From: Anderson - DNR, Katharine <katharine.anderson@state.co.us>
Sent: Thursday, August 27, 2026 2:32 PM
To: Miranda Benson
Subject: Re: FW: Boundary Line Adjustment - County File #EXBL262

I am processing a subdivision exemption project to modify the boundary line between two unplatted but legally created parcels. Public access EDARP file number: [EXBL262](#). Currently, "Parcel C" (southern parcel) has an established well and "Parcel B" (northern parcel) does not.

SHEET 2 OF 2

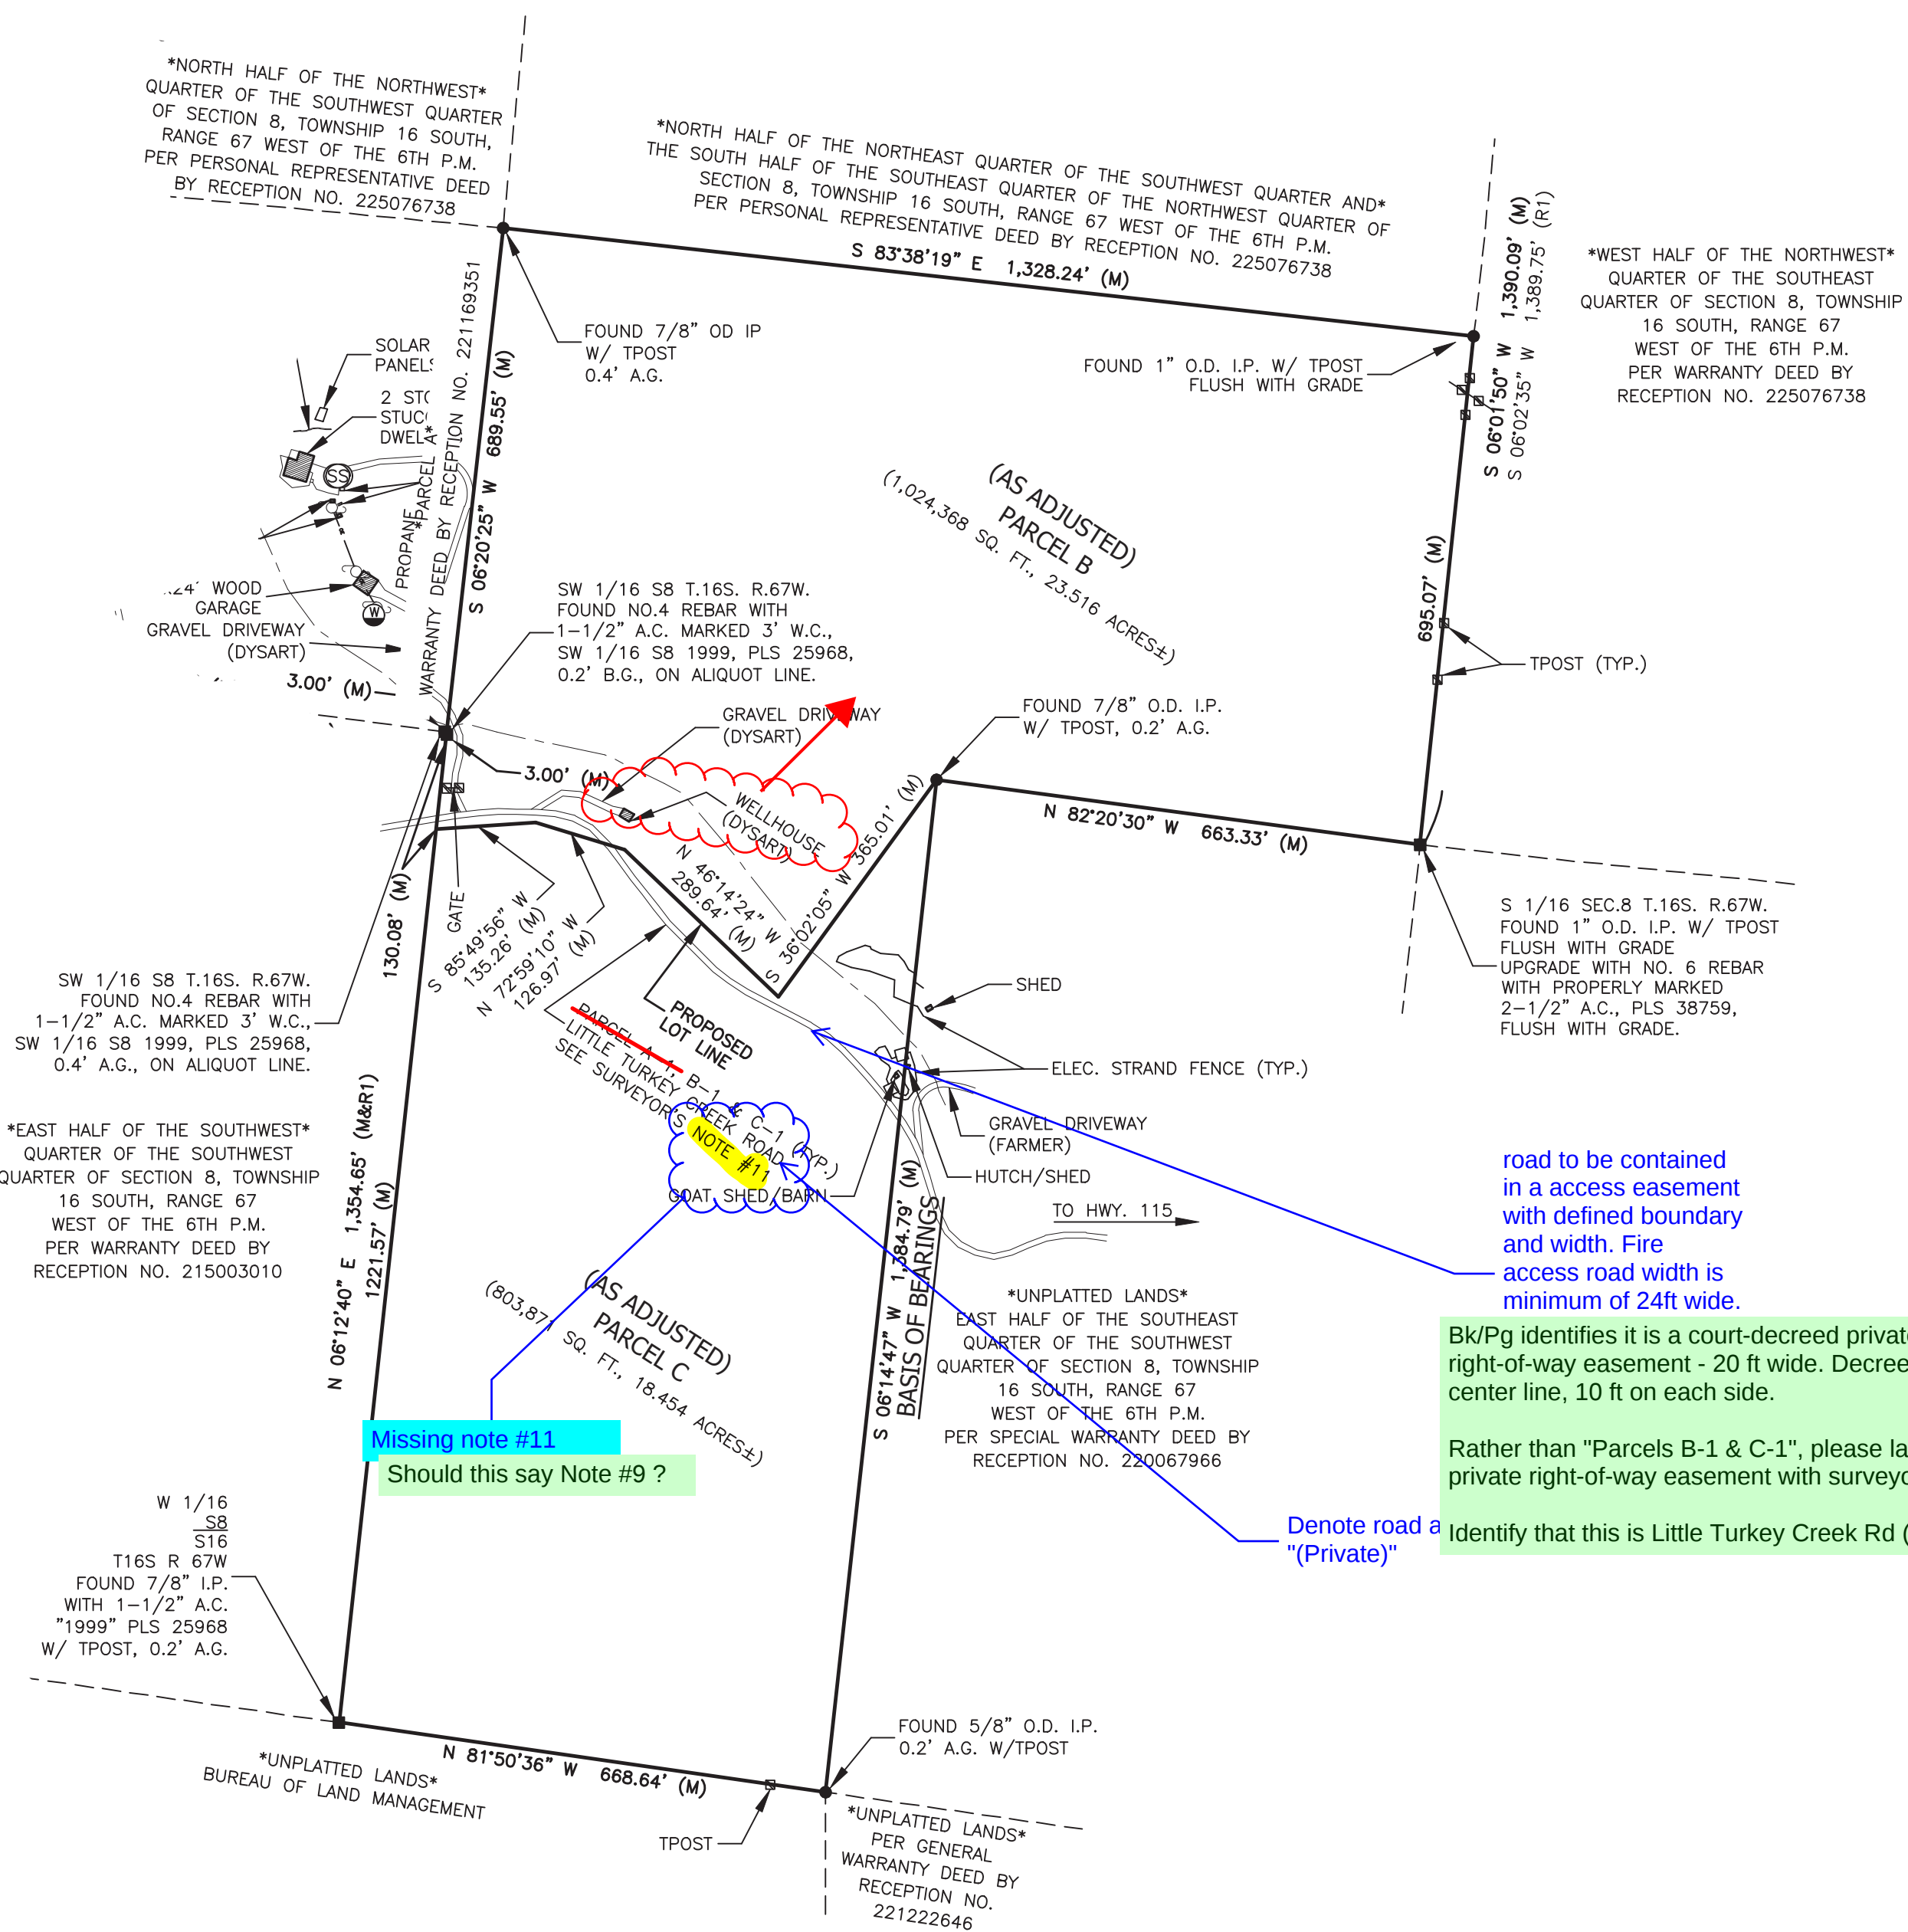
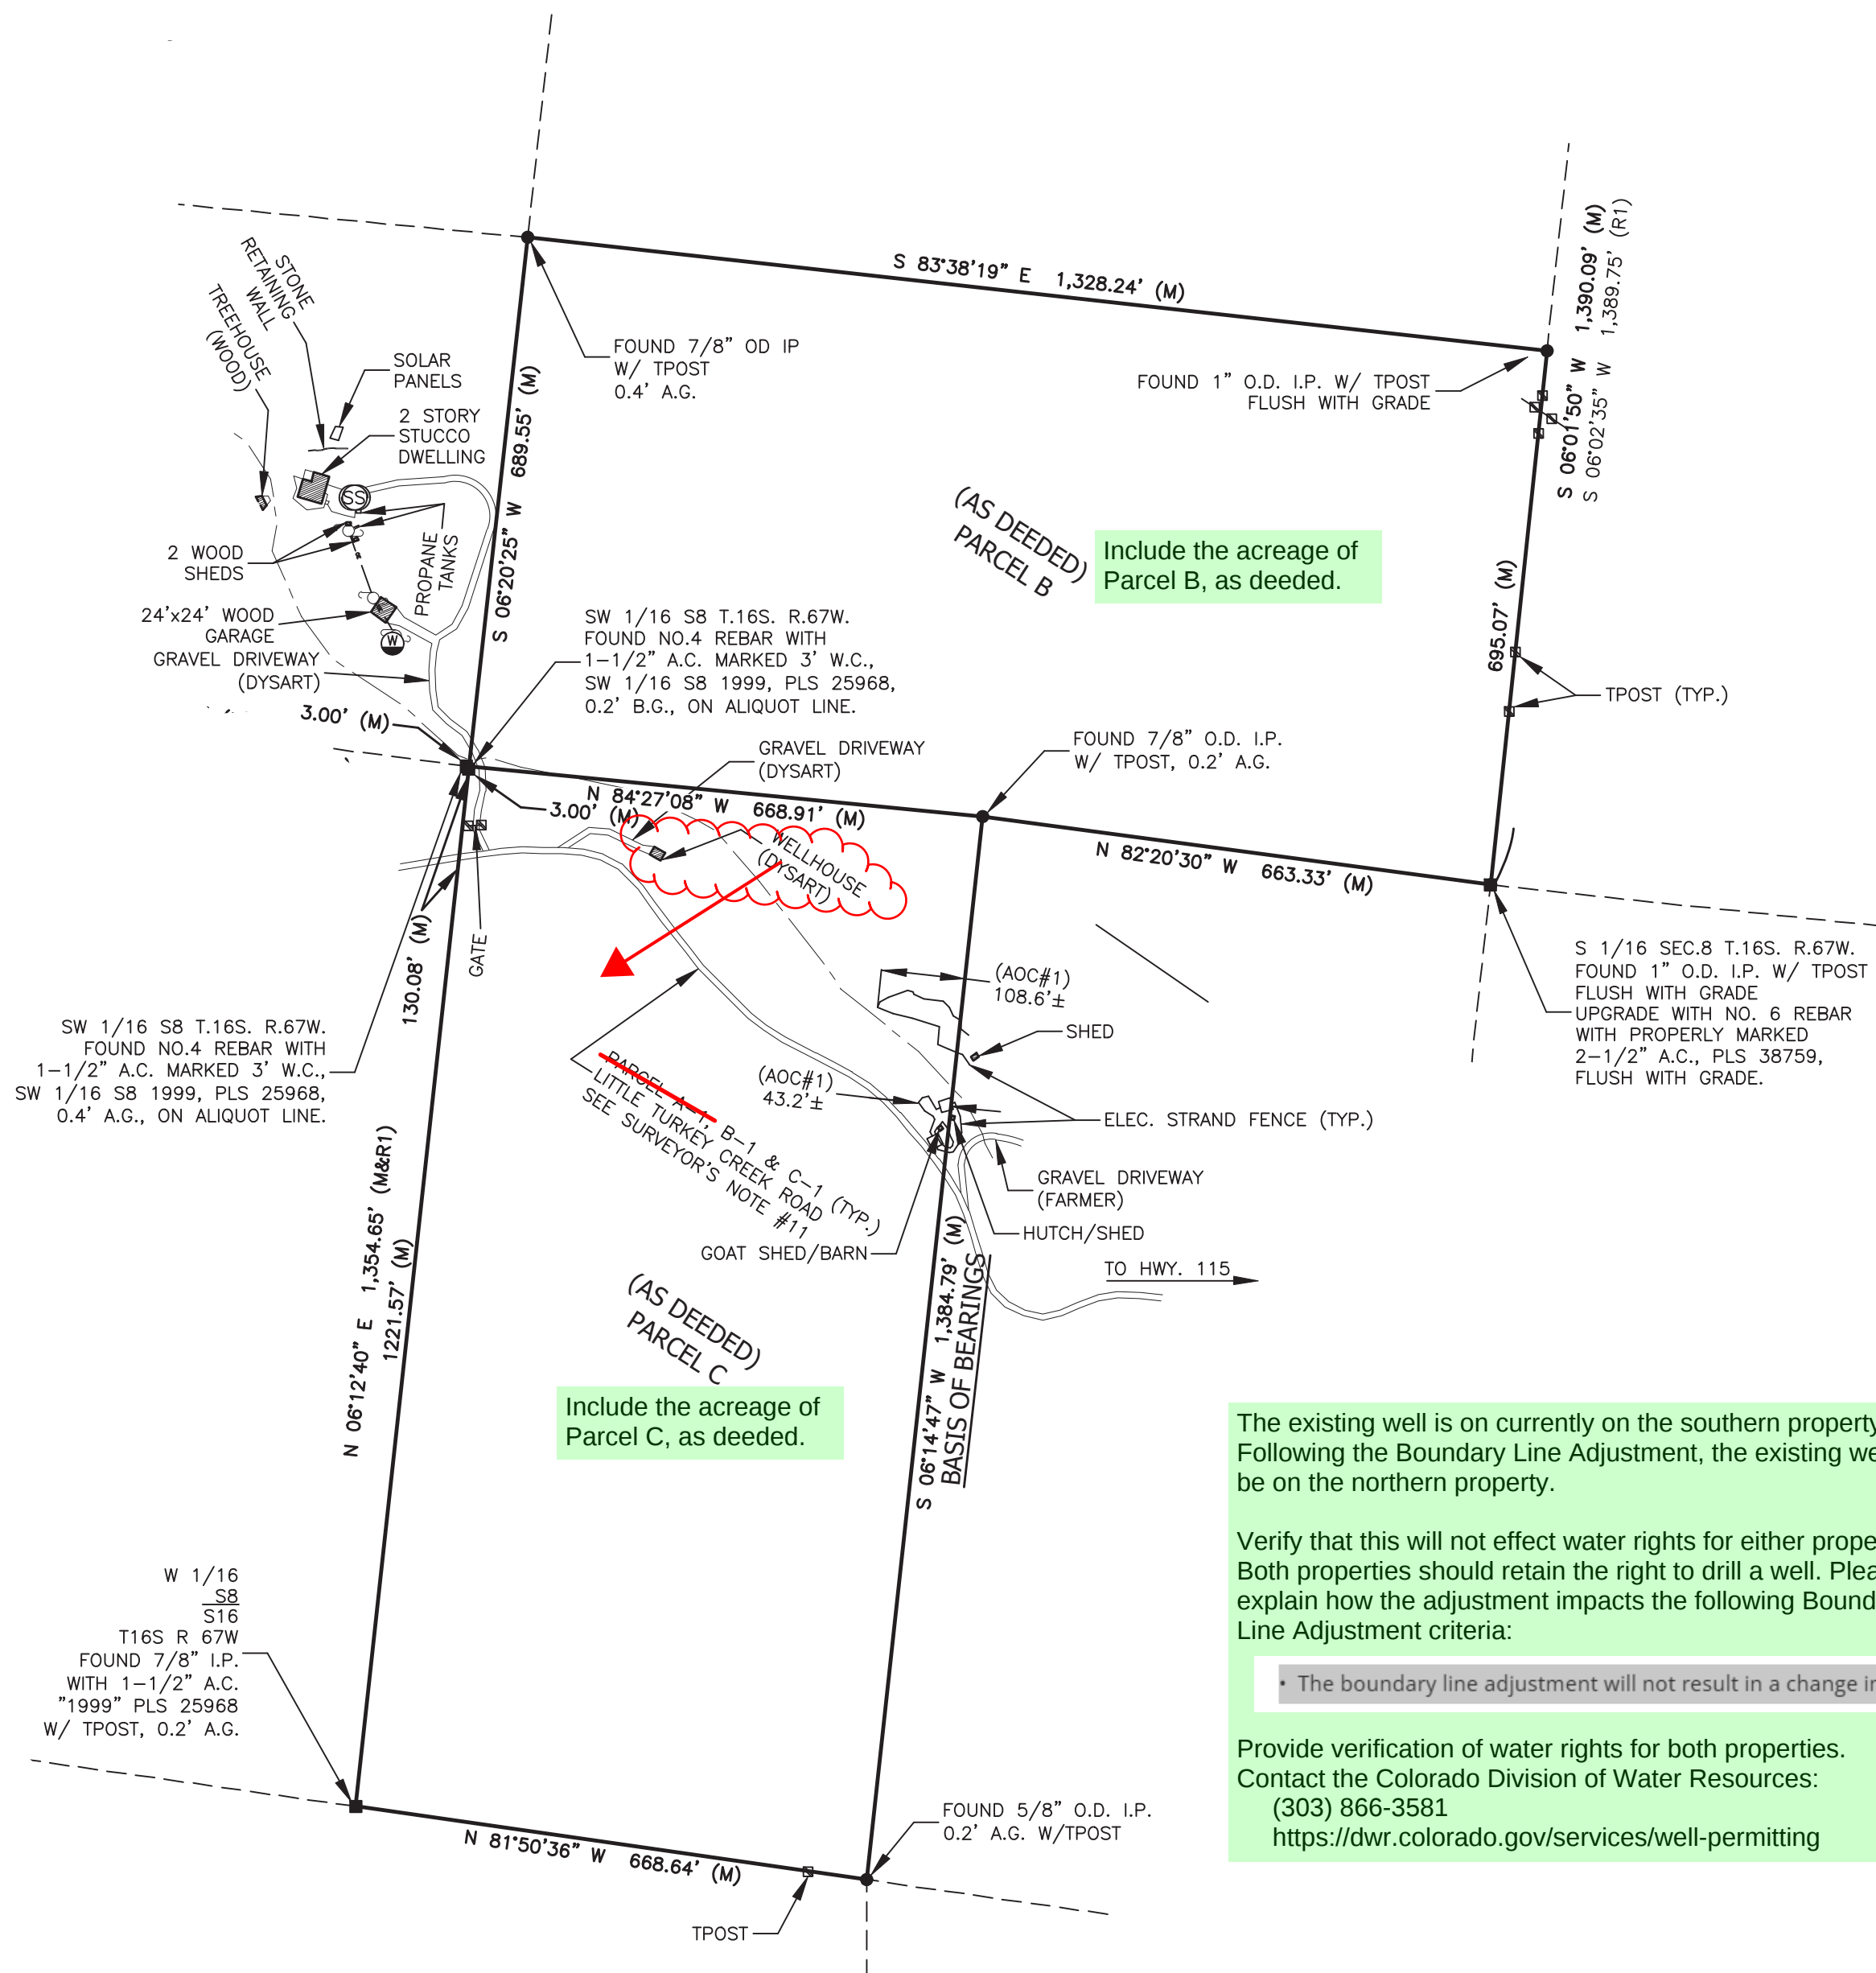
The applicants are proposing to reconfigure the boundary line in a way that the well would then be located on "Parcel B" (northern). Screenshots from the application's map drawing are below.

- Will this boundary line modification impact the water right for either parcel?
- Will Parcel C be eligible for a well permit in the future?
- Is there a process that needs to be completed to transfer ownership of the well/water right from Parcel C to Parcel B?

Well permit no. 173792 is associated with Lot 22 of Eagles Nest Subdivision. The well permit is associated with both the legal lot name as well as the current area, shown below in pink (the "well encumbrance area"):

After the lot line adjustment, the well will no longer reside on what is currently known as Lot 22, and a portion of both parcels will be encumbered by the existing well permit. The entire southern parcel would be encumbered by a well that does not reside on the property, rendering it ineligible for an exempt permit, and unable to obtain a water supply through an exempt well.

To fix this, the easiest route would be to have the owner of the northern parcel re-permit the well based on the new parcel boundaries and legal description. This will update the well to be associated with the northern parcel, and it will un-encumber the current pink area of the southern lot by instead encumbering the entirety of the northern parcel. Although we cannot guarantee well permits over email, unencumbering the land of the southern parcel would allow the southern parcel to possibly obtain an exempt well permit some time in the future. If this does not happen, the southern parcel would definitely be ineligible for an exempt well permit because we cannot legally issue two exempt permits within one encumbrance area.
